**Talavera Road Data Centre Campus Expansion (SSD-24299707)
Additional Matters for Submissions Report**

ATTACHMENT 1

Based upon the Department's review of the information of the EIS, the Department considers further information is required to clarify matters and addresses inconsistencies within the documentation. In this regard the following information is required to be provided:

A1301

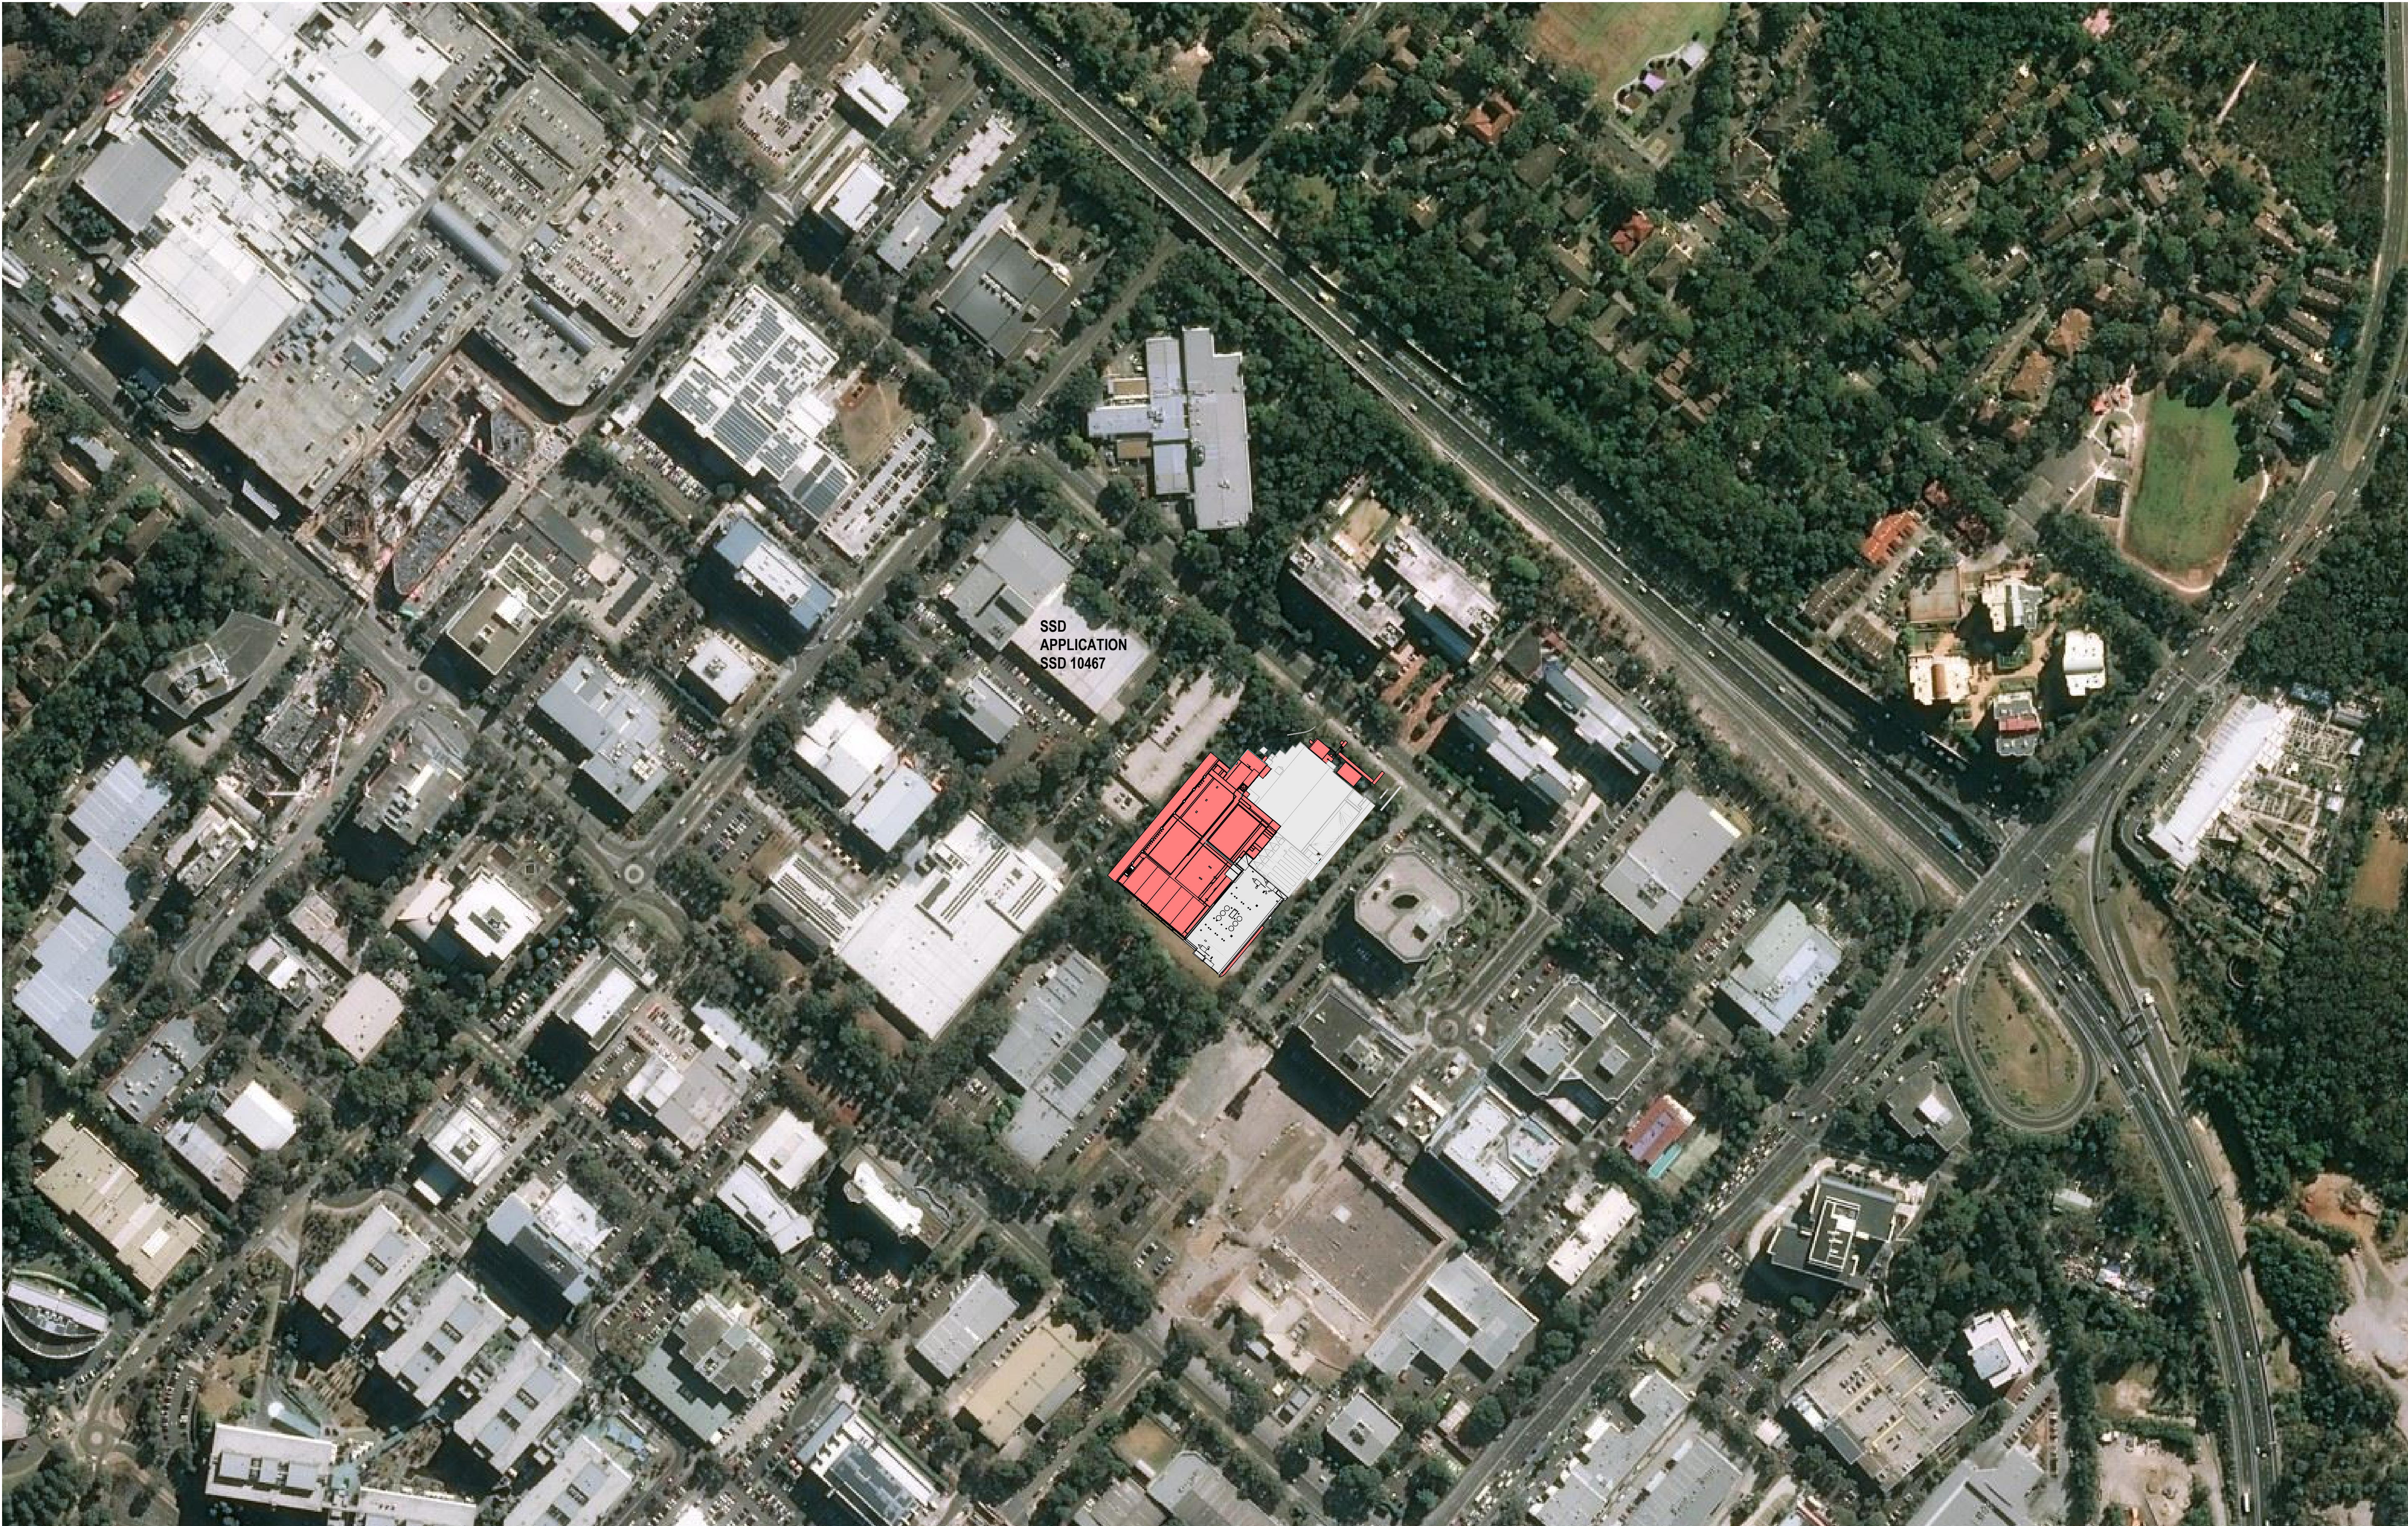
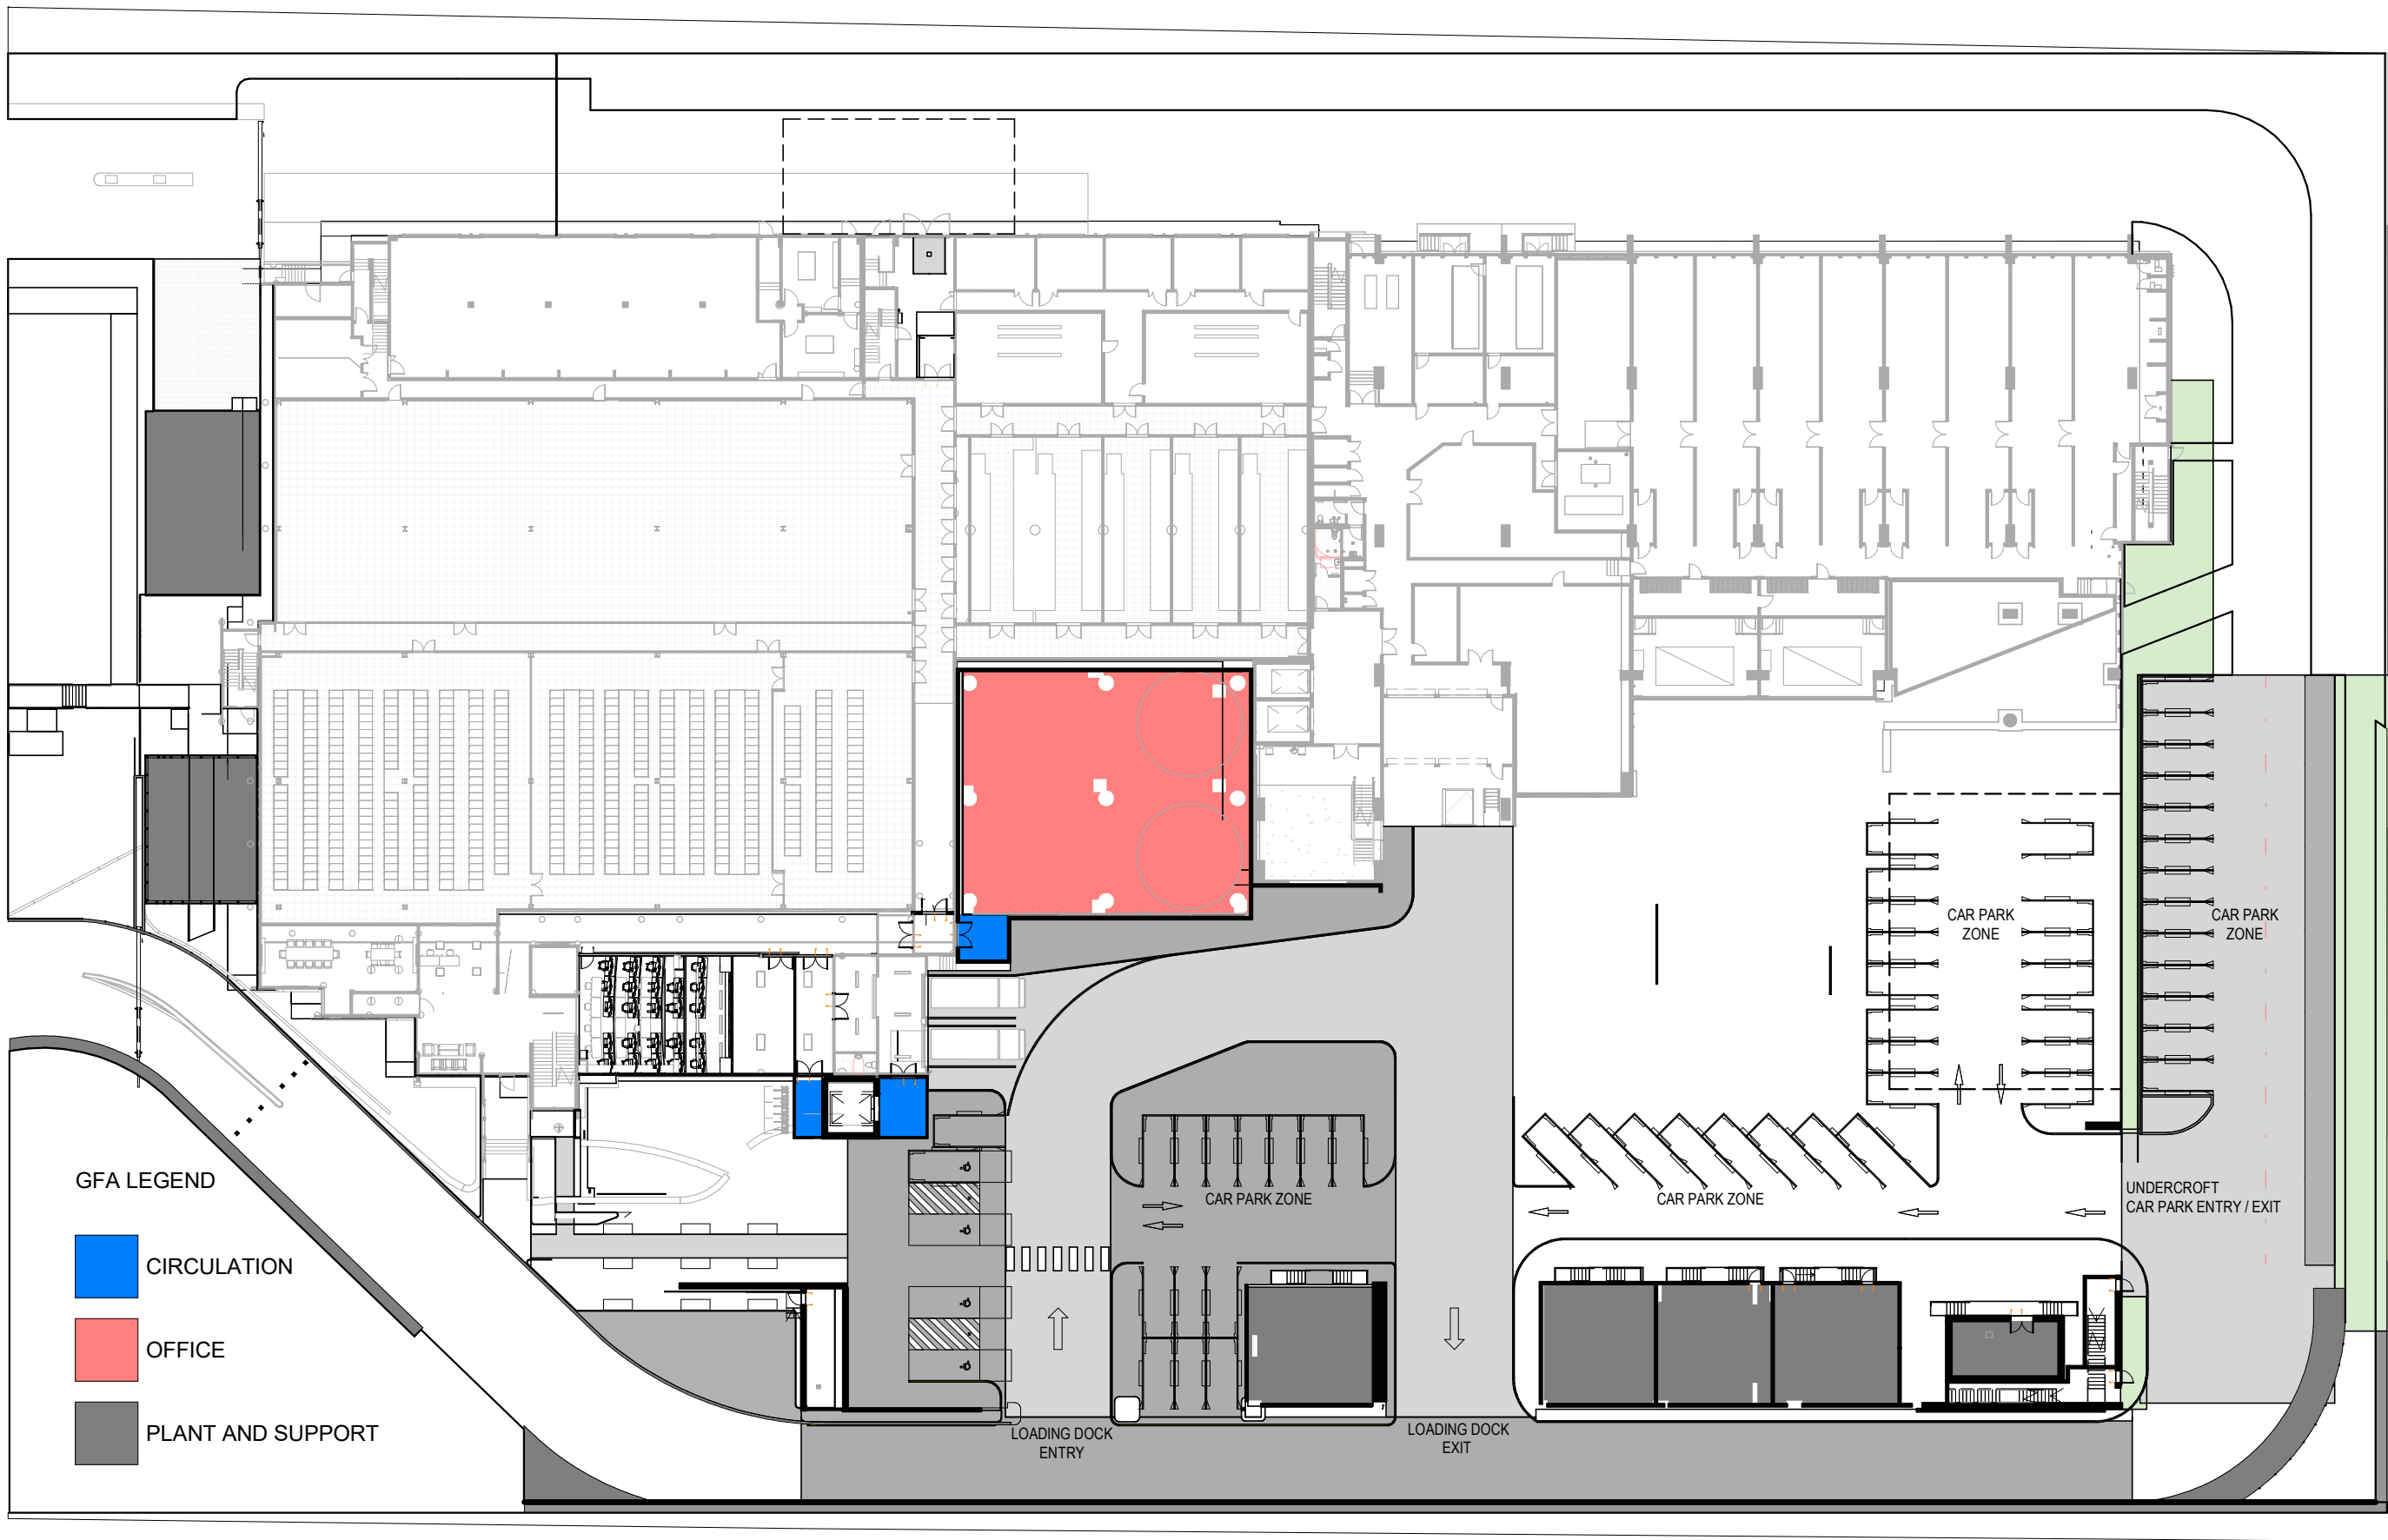
30. The Department notes the GFA figures referred to in the EIS differ slightly from those figures referenced in the architectural plans. Please clarify accordingly.
31. The Department notes the number of proposed construction jobs (1,200 jobs) is significantly higher than comparable projects in the surrounding area. The Submissions Report should clarify the assumptions which have informed this number.
